March 5, 2018

**Re: Drainage Conformance Letter for Lot 1, Block 1 – Claremont Ranch West
Filing No. 9B**

VICINITY MAP

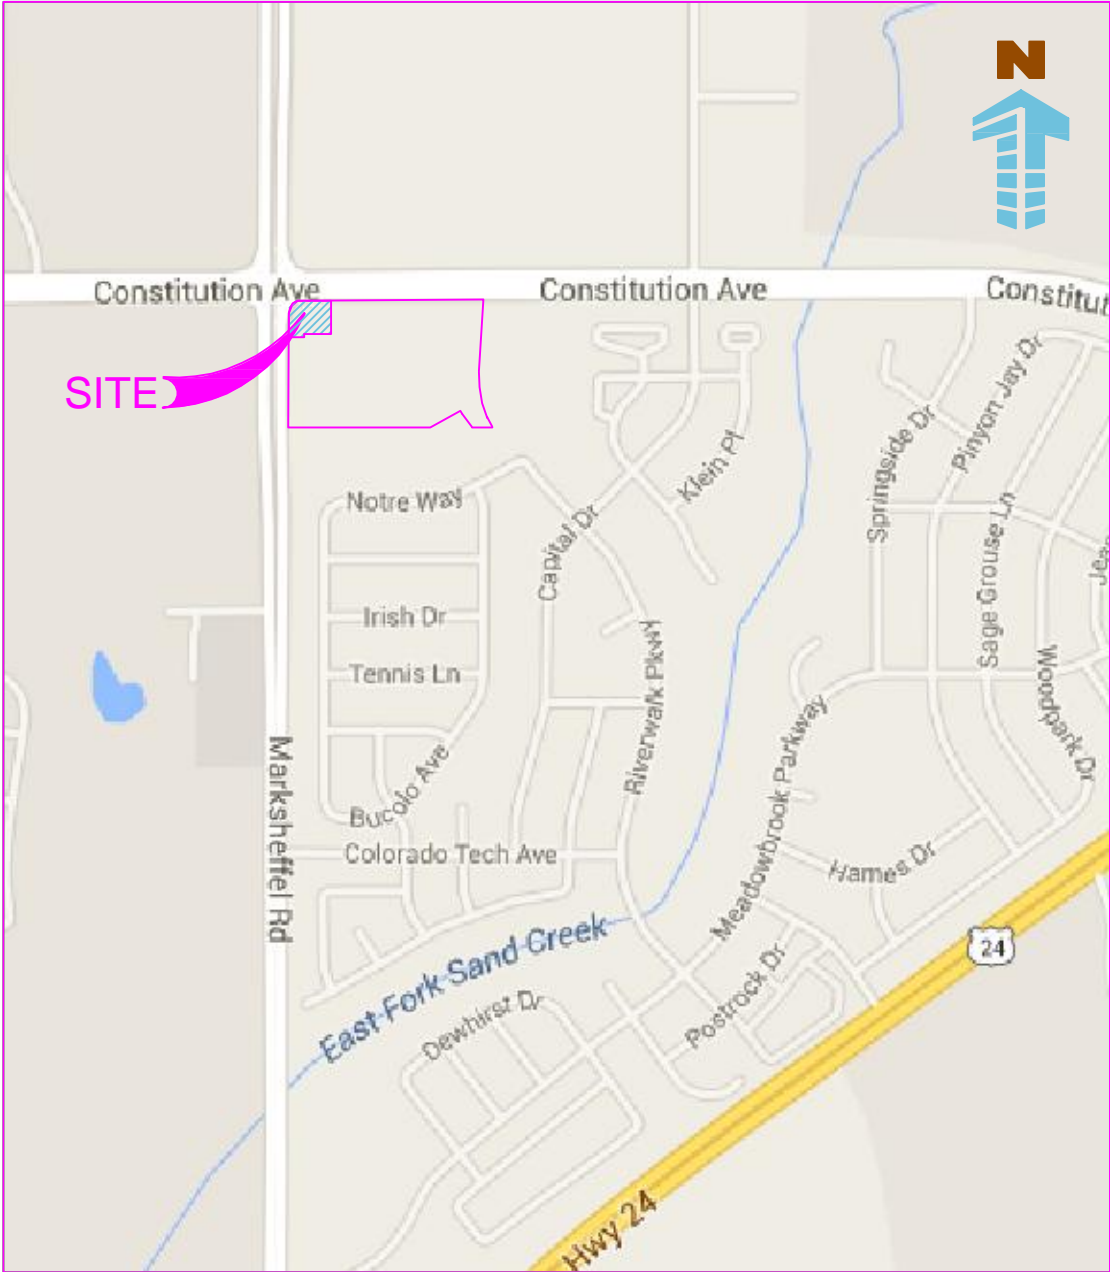
Include a vicinity map
